Planning Inspectorate
BUCKINGHAM AVENUE, SLOUGH, SL1
4PN

Reference: OR-0012808/01
Customer reference: EN020026

All-interested parties consultation following the 28 August 2026 request for information.

Sea Link

**Figure 1.1 Application Document 2.13.2 Design and Layout Plans – Kent Indicative Horizontal Direction Drill Solution Pegwell Bay.**

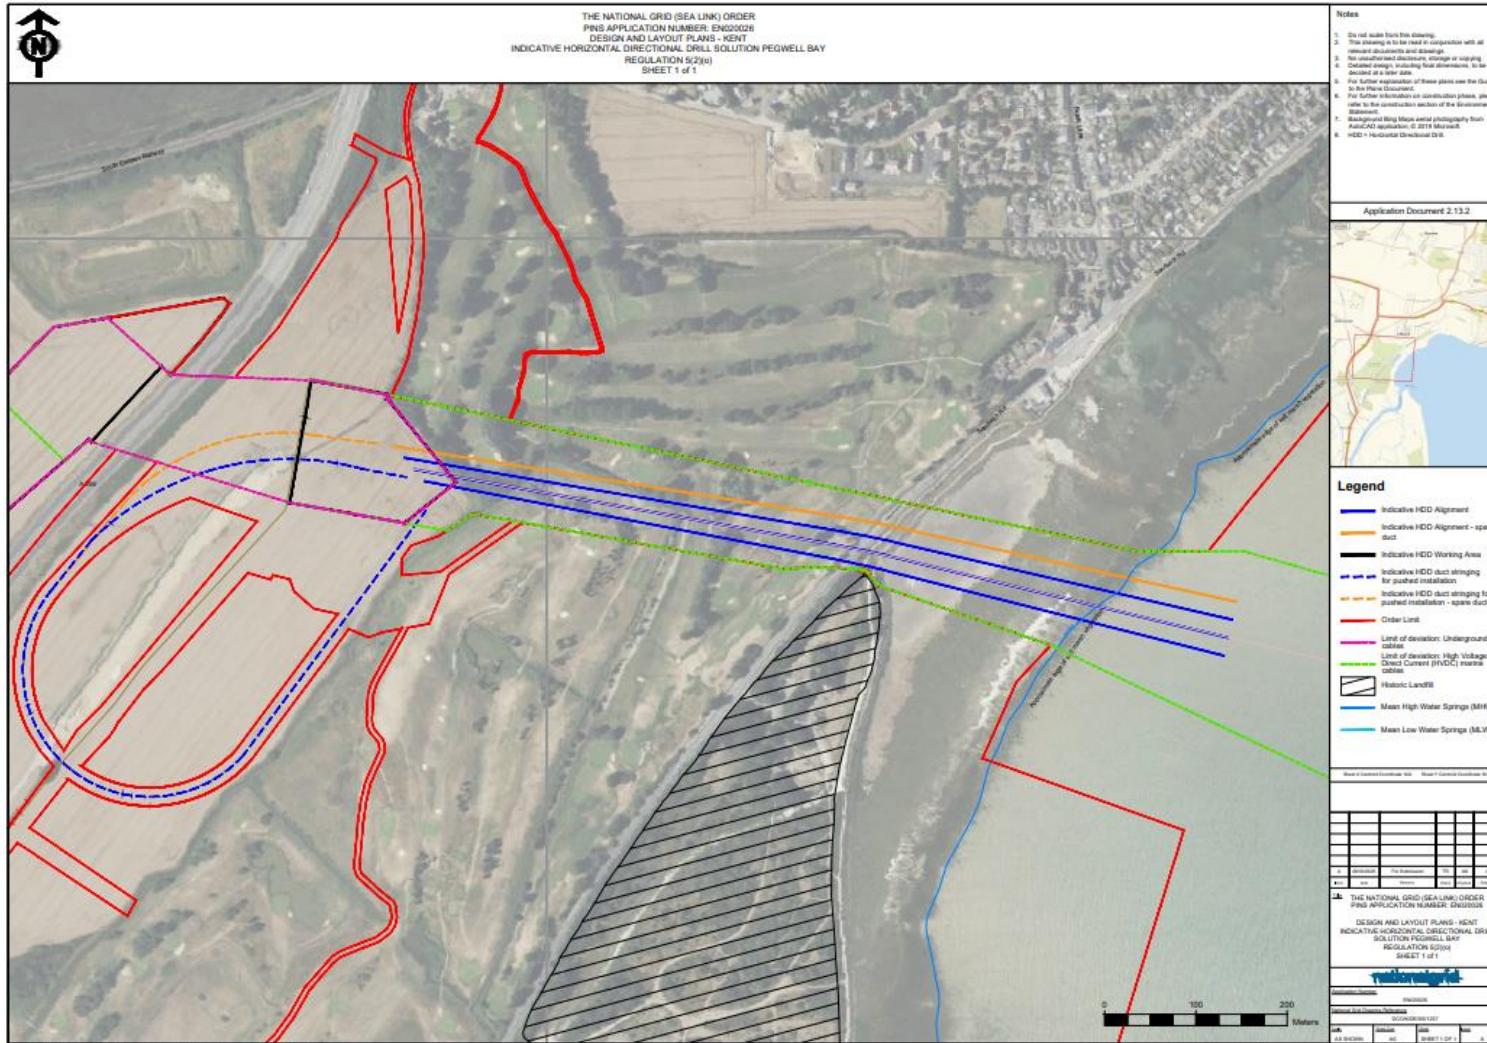
We are satisfied that the two proposed HDD exit points within Pegwell Bay would result only in localised and minor impacts on the geomorphology and conservation interests of the sandflat and mudflat habitats, under normal operating conditions. From a Water Framework Directive perspective, these impacts are not considered significant. We note, however, that Natural England may wish to provide separate comments regarding ecological impacts.

For the avoidance of doubt, we would not approve of mitigation involving training walls, lateral erosion protection works, or any proposals intended to constrain the natural migration of the estuary channel. This position would include any proposals to protect HDD exit points from lateral erosion. The continued operation of natural estuarine processes is considered important and should not be compromised.

While we consider the HDD exit points would result only in localised and minor impacts under normal operating conditions, the Applicant should demonstrate that robust measures are in place to prevent and manage any drilling fluid breakout events.
